# OXFORDSHIRE COUNTY COUNCIL'S RESPONSE TO CONSULTATION ON THE FOLLOWING DEVELOPMENT PROPOSAL

**Application no:** 22/03063/F

**Proposal:** Erection of 126 dwellings with access from Camp Road, provision of public open space and associated infrastructure

**Location:** Land East Of Larsen Road, Heyford Park

Road 3  
Horiz. 1:500 Vert. 1:50

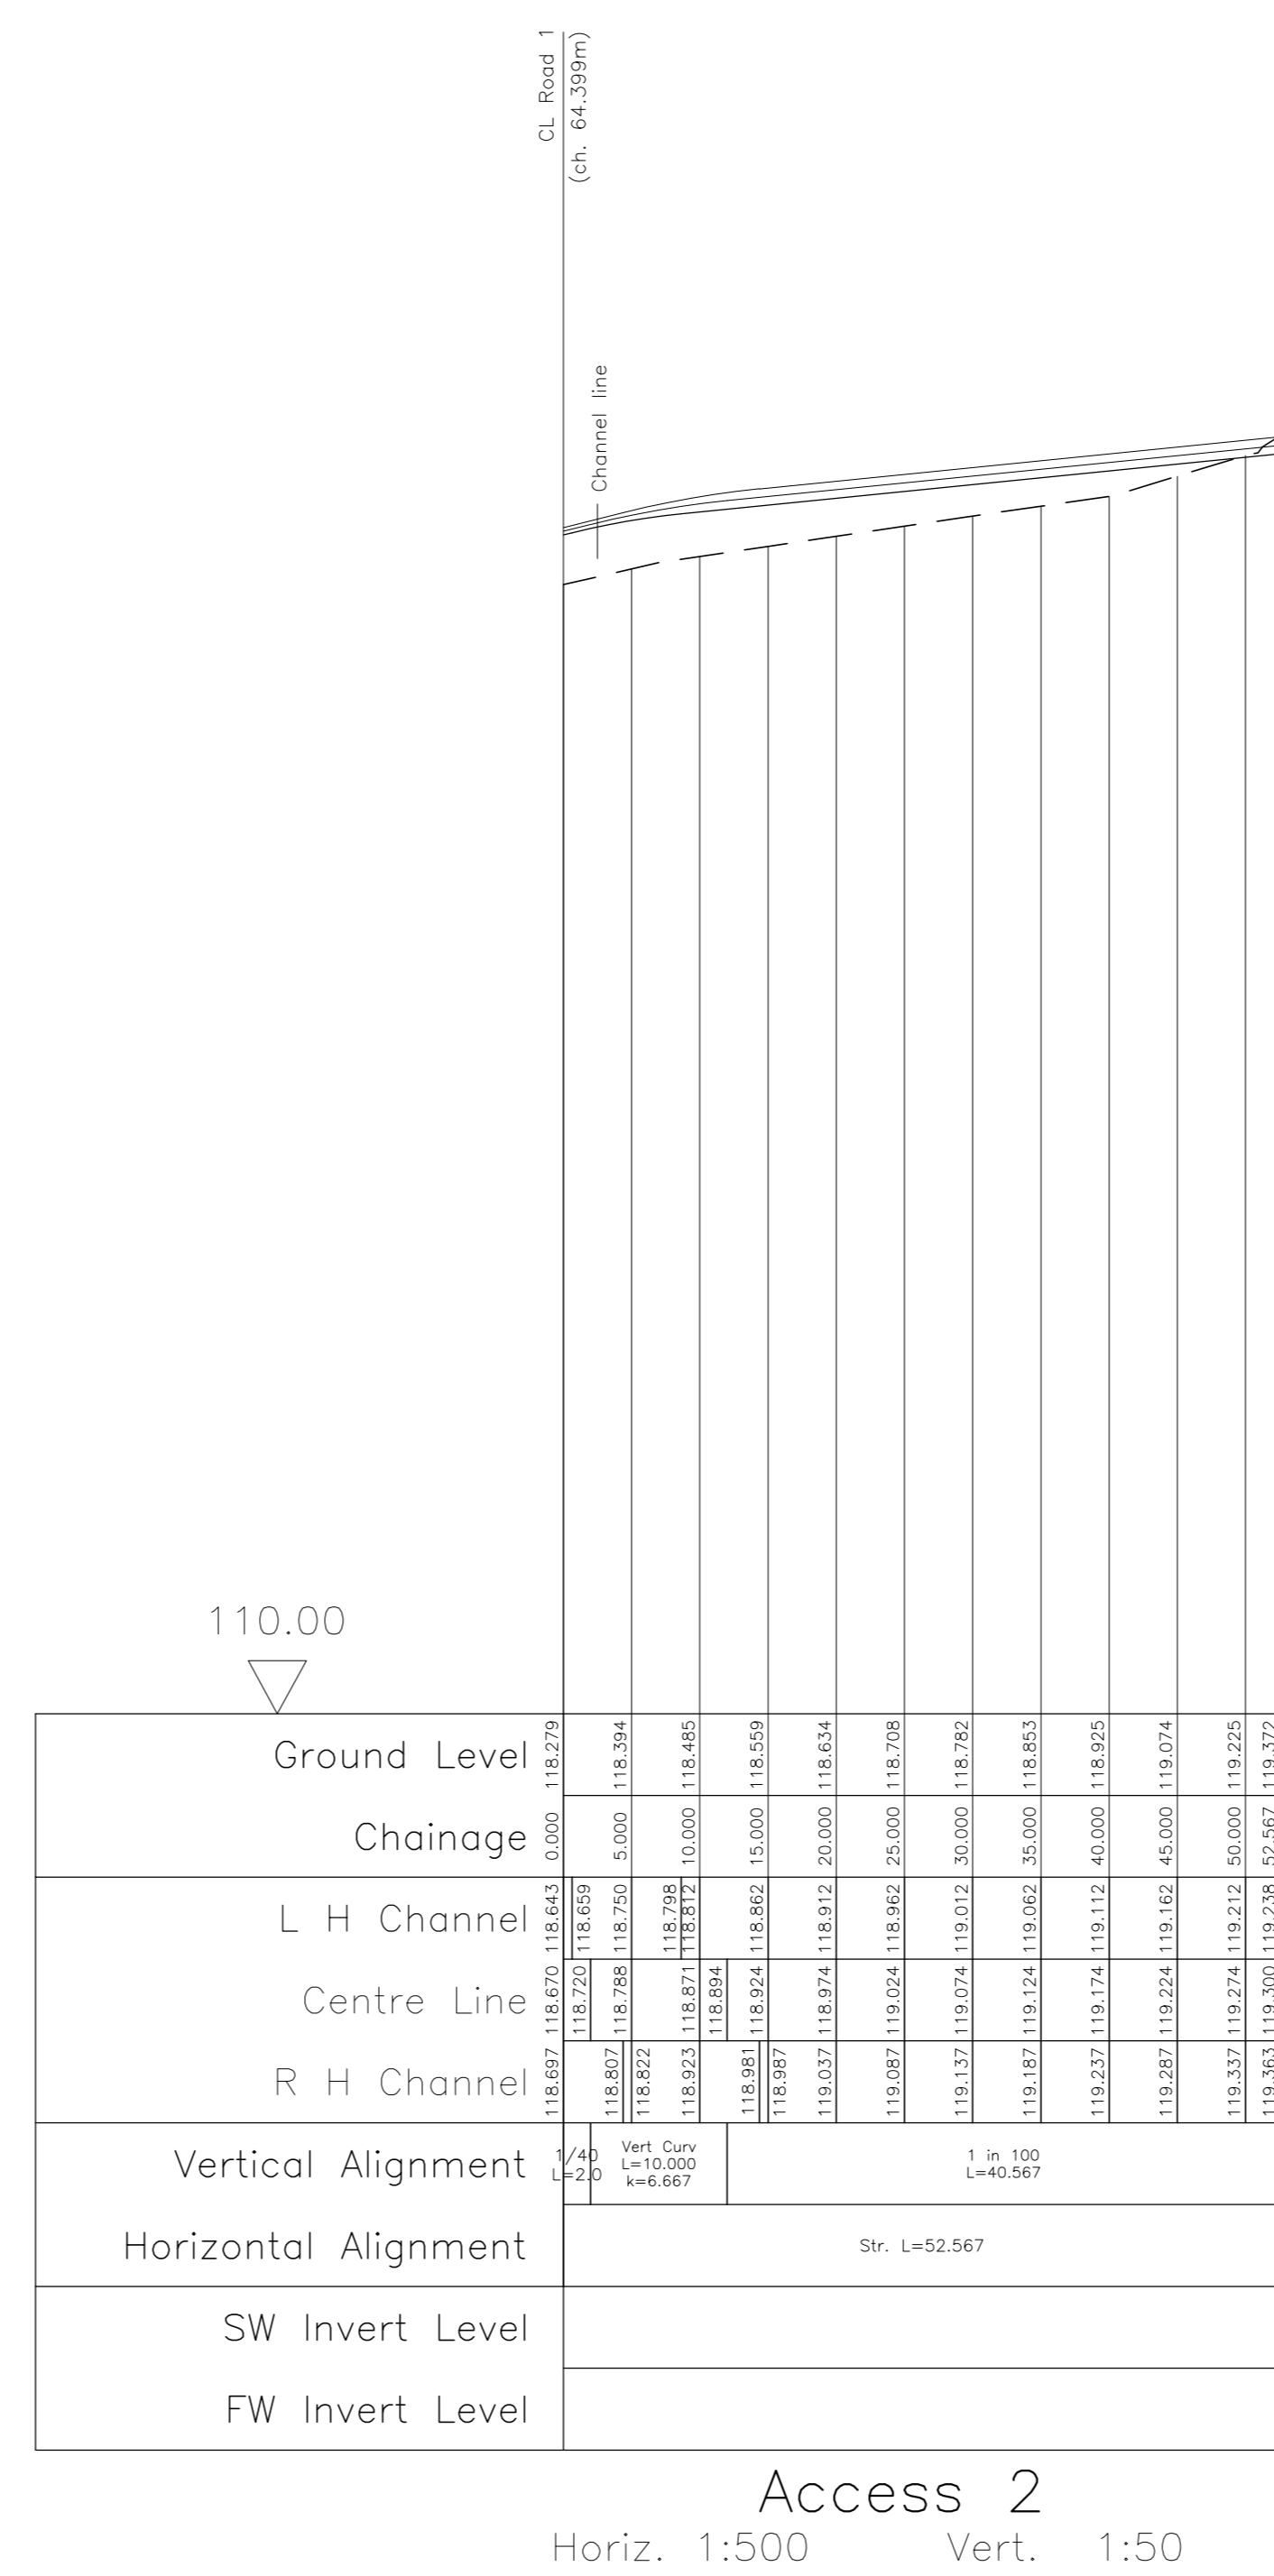
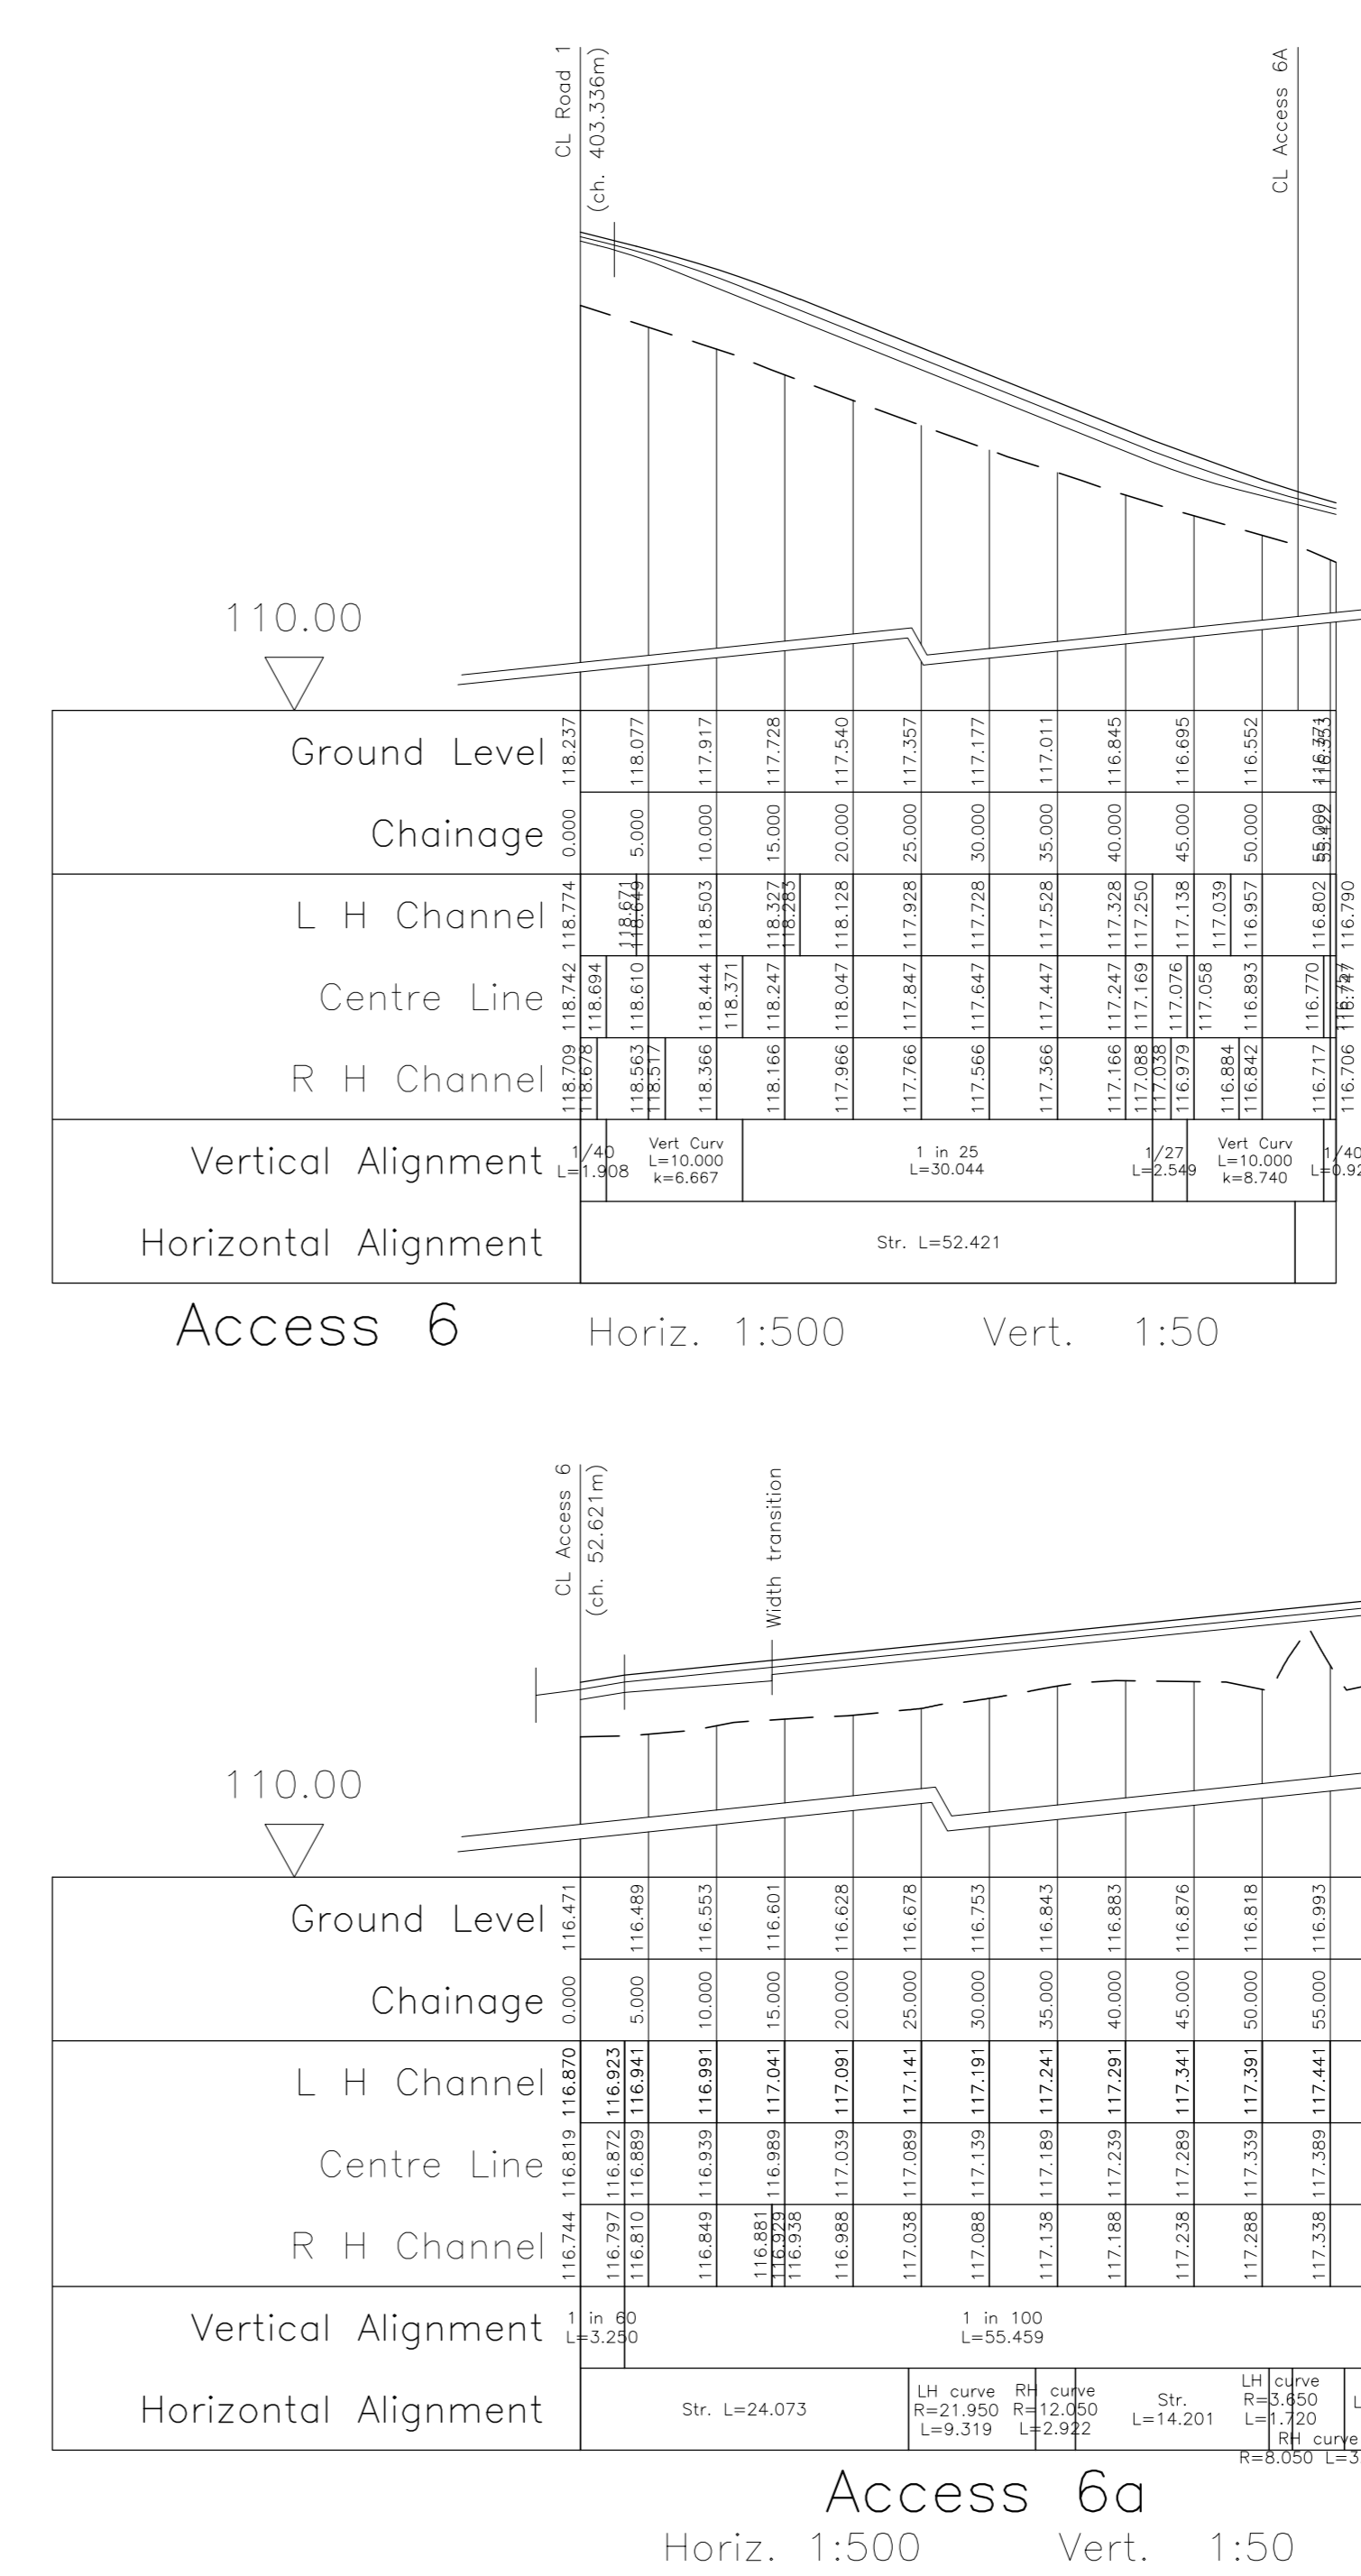
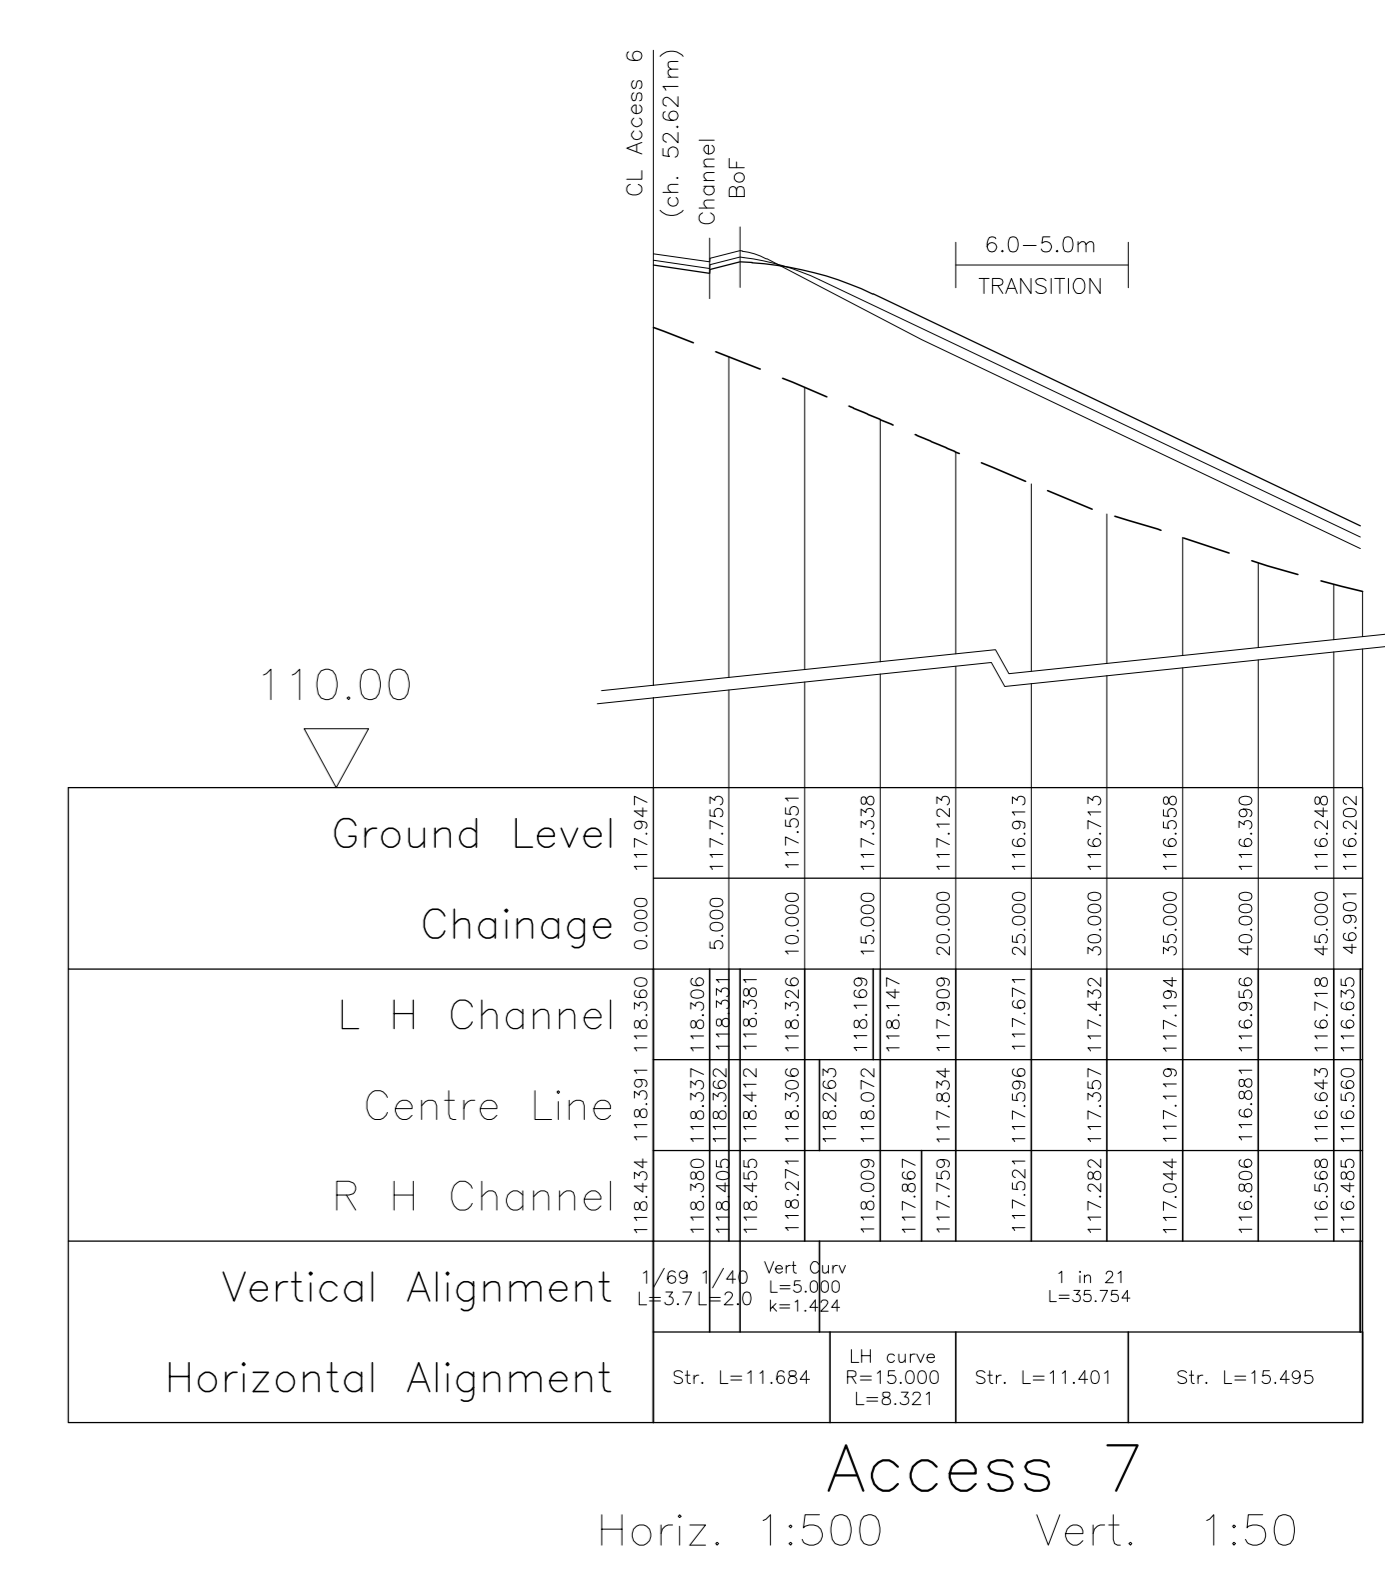
- A long section indicating the vertical alignment will be required to determine appropriate carriageway and footway gradients. They will need to be DDA compliant i.e. maximum 1:20 or 5%.
